**PAD-3**  
**PADMARK BUSINESS PARK - LOT 3**  
 1190 MEADOWBROOK PKWY  
 COLORADO SPRINGS, CO 80915  
 EL PASO COUNTY, COLORADO

90% REVIEW SET; NOT FOR CONSTRUCTION

**Subject:** Cloud+  
**Page Label:** [4] Padmark Lot 3 - Electrical - 082718-ES-1  
**Lock:** Unlocked  
**Author:** dskendall  
**Date:** 10/5/2018 3:04:15 PM  
**Color:** ■

- 1 PHOTOMETRIC SITE PLAN
8 SCALE: 1/16" = 1'-0"

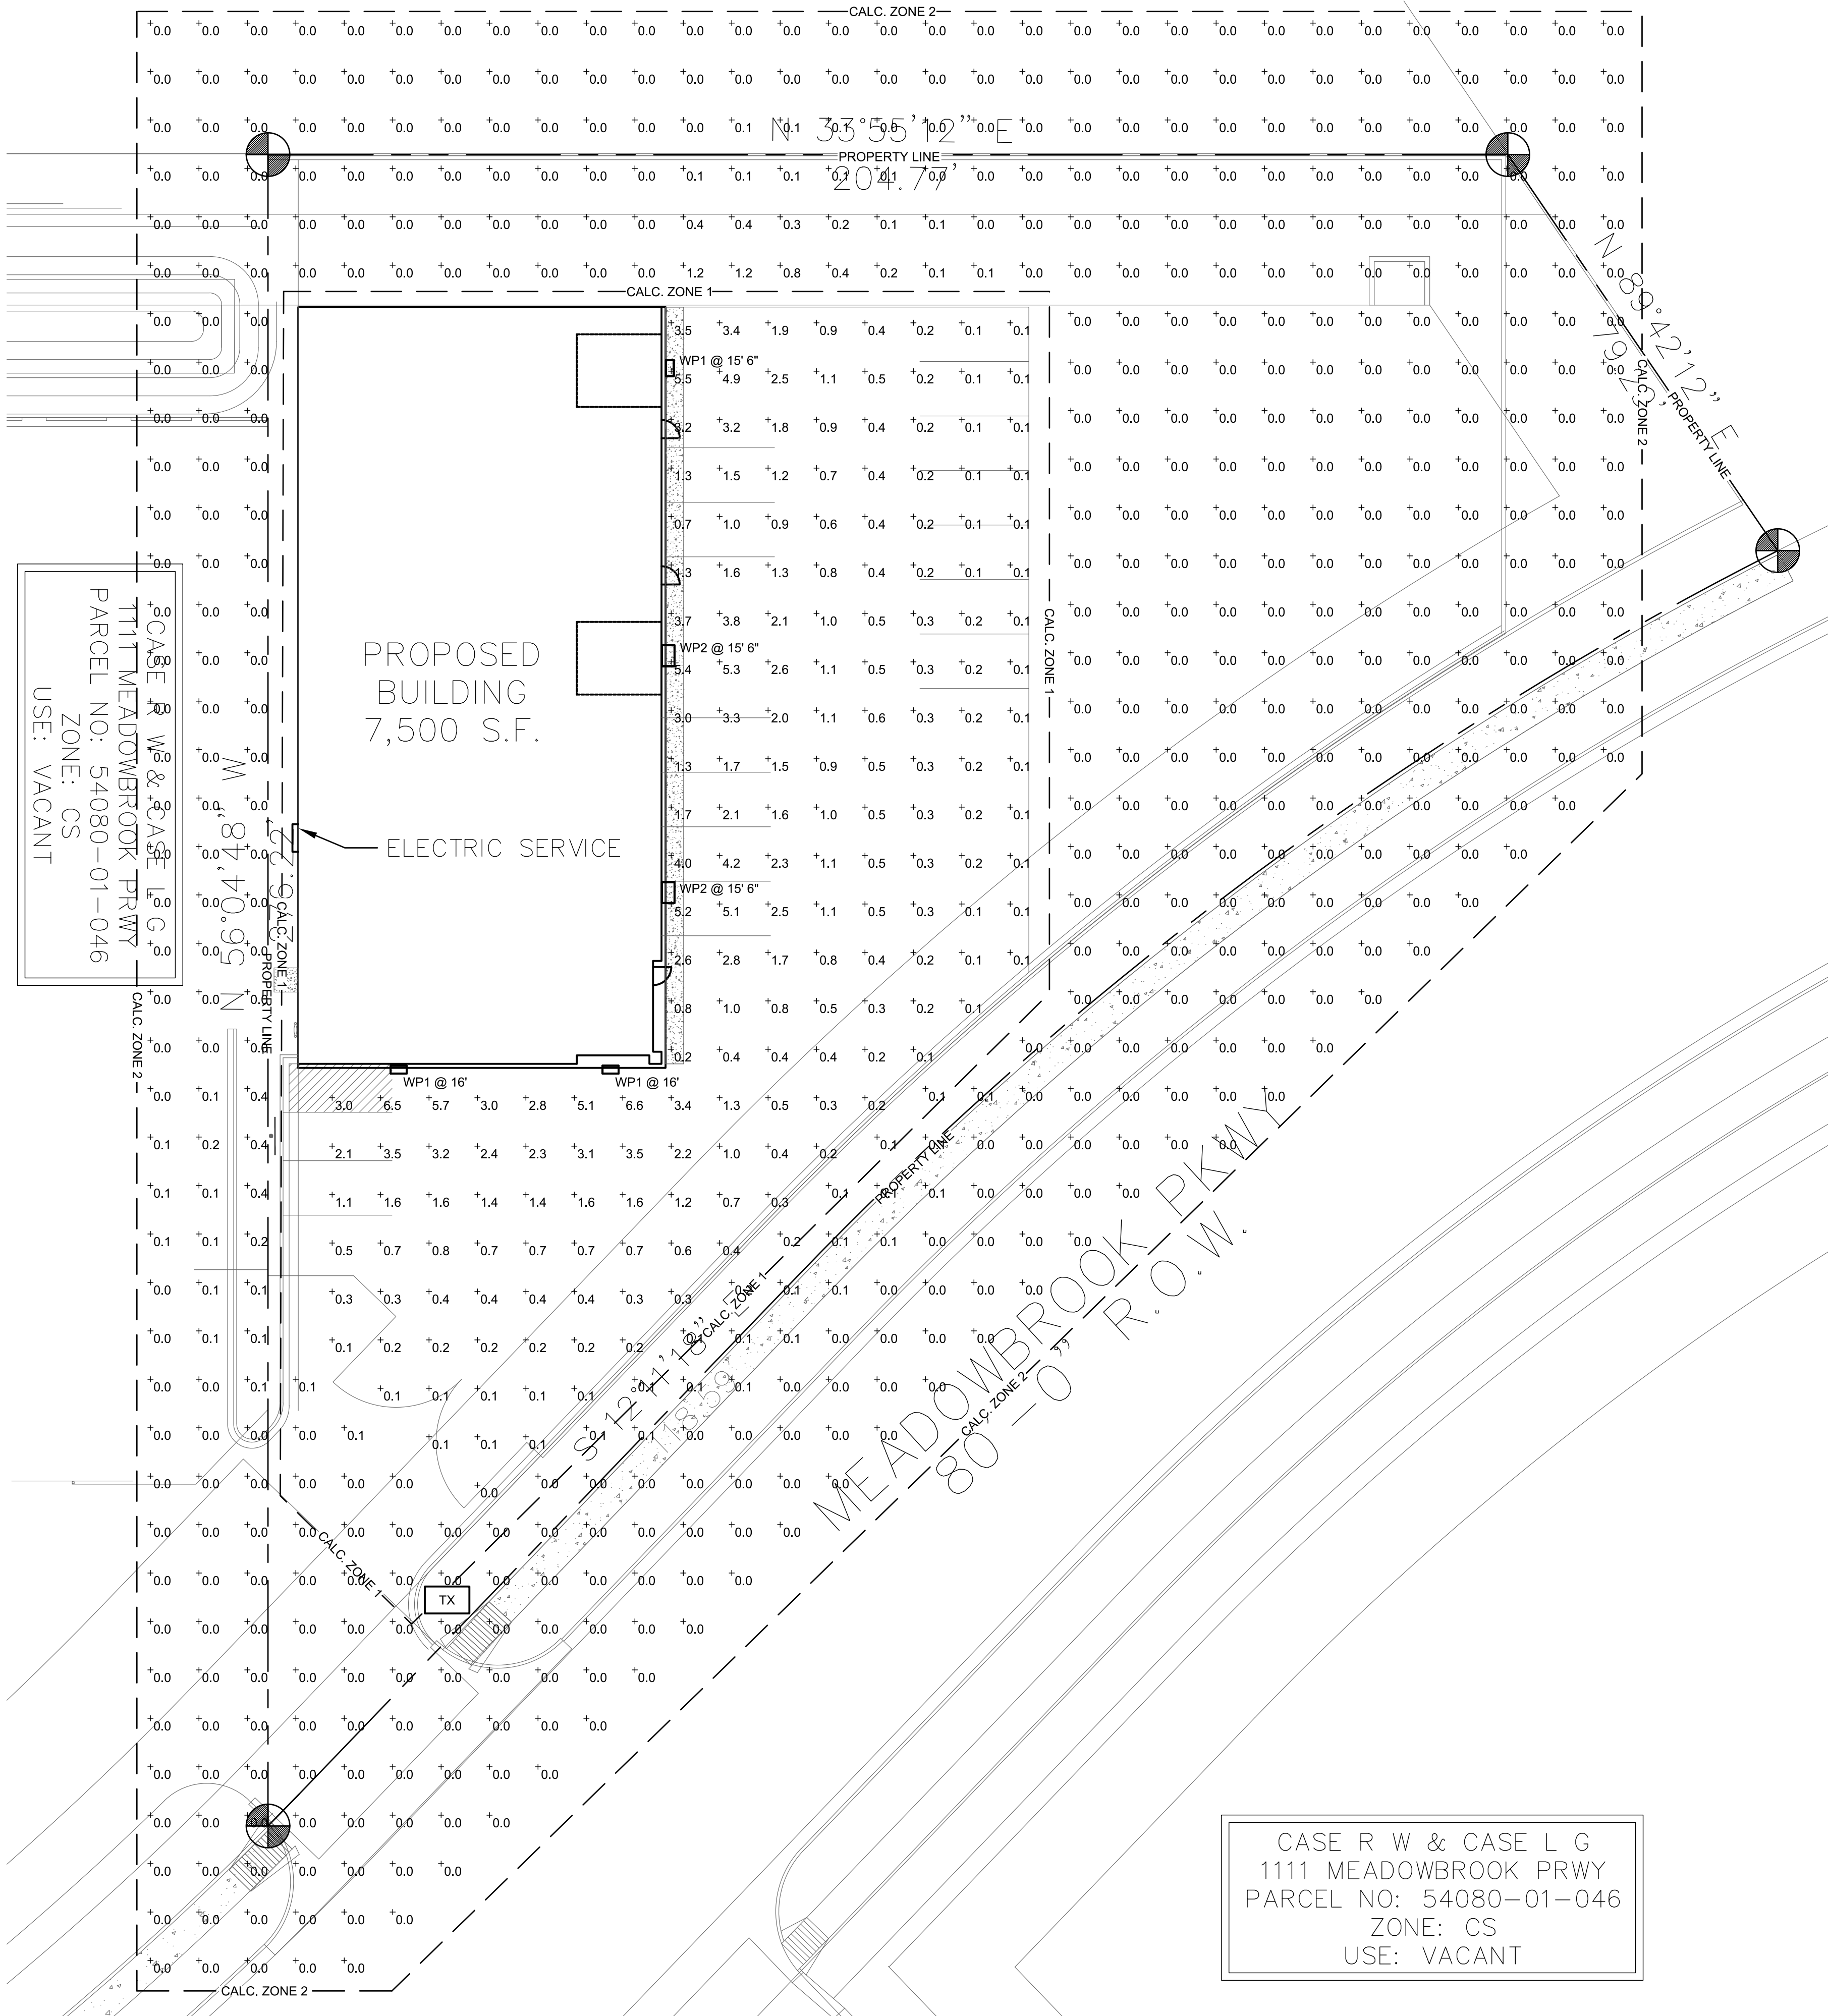
Cannot exceed 0.1 foot candles at the property boundary when adjacent to public right of way.
